KITTITAS COUNTY FIRE MARSHAL'S OFFICE

Fire Marshal comments

Project Name Silver Ridge Ranch

Case Number CU-24-00006

DATE: 3/8/2024
SCALE: 1" = 30'
SHEET: SP-2

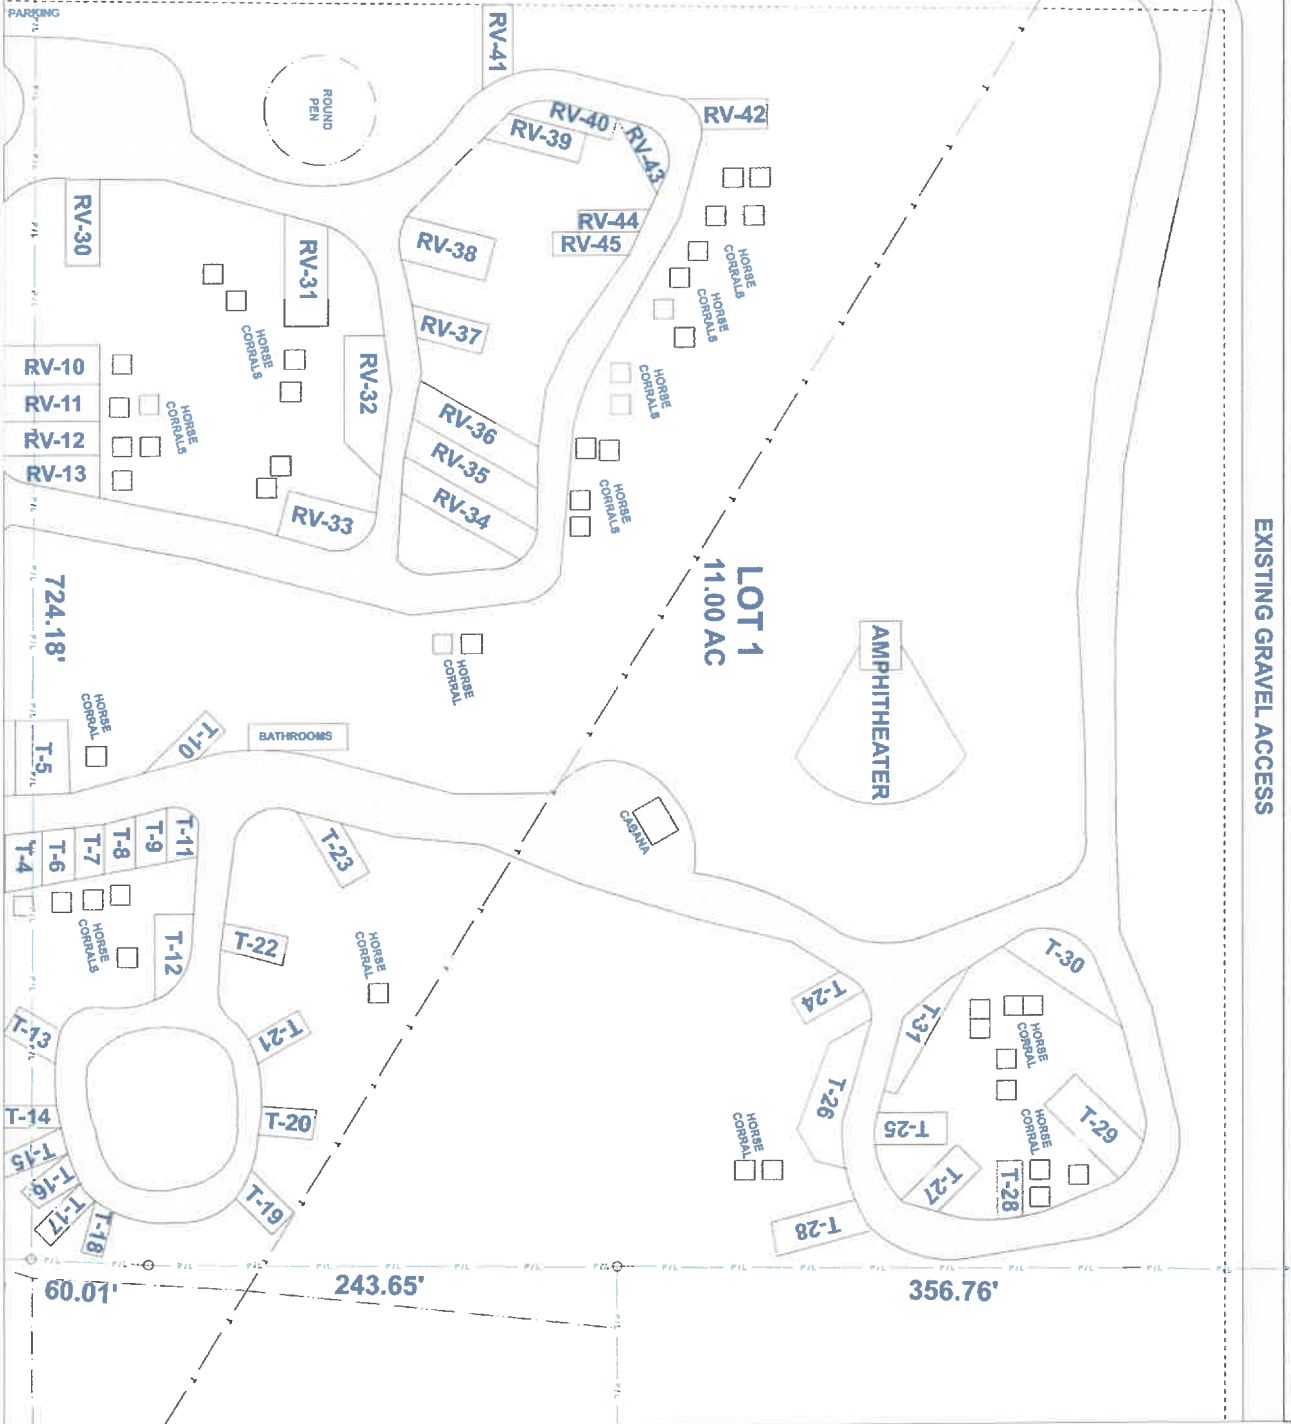
Fire apparatus access is required for this application. The roadways and maneuvering areas as indicated in the application do not adequately provide required fire apparatus access. Provide fire apparatus access roads with an unobstructed width of not less than 20 feet, an unobstructed vertical clearance of not less than 13.5 feet, with an all-weather driving surface and capable of supporting the imposed loads of fire apparatus. Access roads shall extend to within 150 feet of all portions of the facility and all portions of the exterior walls of the first story of the building. Roads constructed in grades steeper than fifteen percent (15%) shall be constructed with Portland cement concrete with grooved surfacing.

SP-3

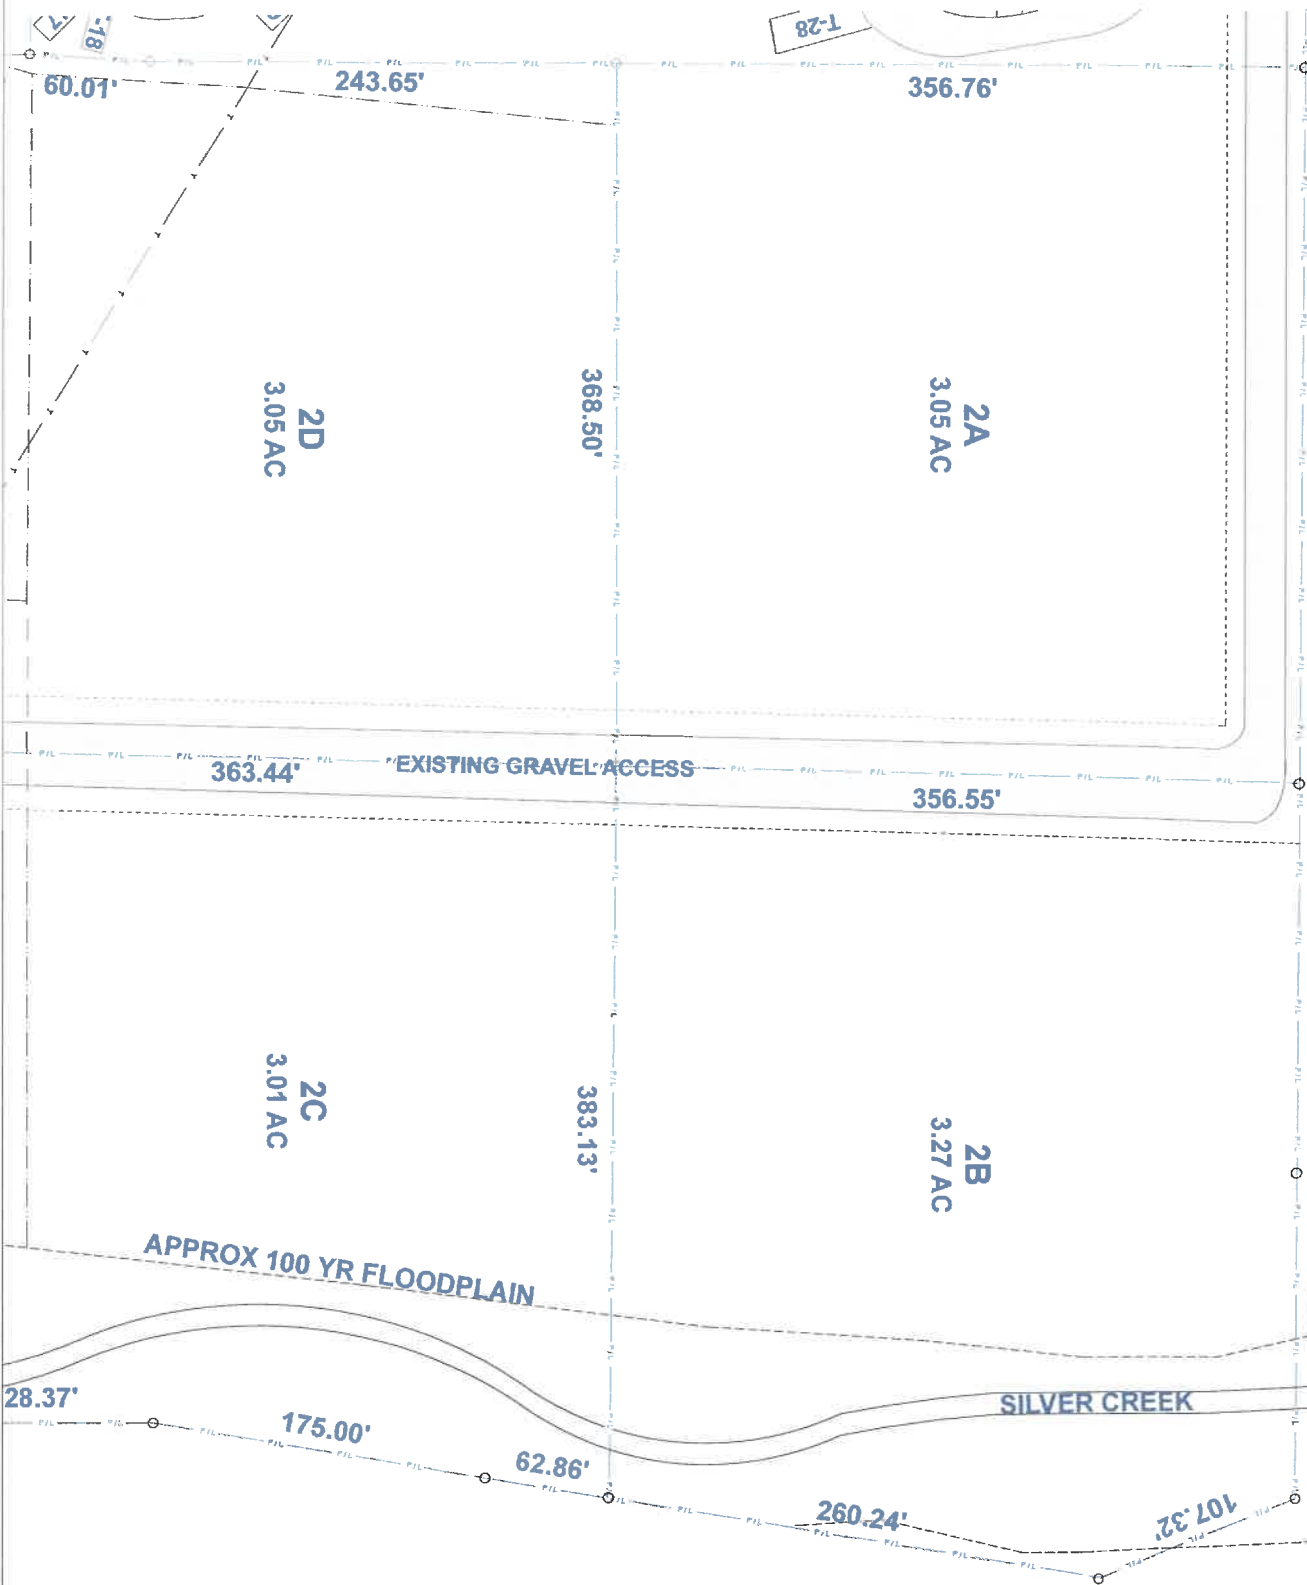
The following requirements pertain to the event venue. If any of the following criteria are met, fire sprinklers shall be required. Such systems require separate reviews, permits and approvals issued by the fire marshal's office.

Group A-3 Occupancy – 903.2.1.3

1. The fire area exceeds 12,000 square feet.
2. The fire area has an occupant load of 300 or more.
3. The fire area is located on a floor other than a level of exit discharge serving such occupancies.

As an A-3 occupancy, if occupant load is 300 or more, a fire alarm and detection system shall be required. Such systems require separate reviews, permits and approvals issued by the fire marshal's office.
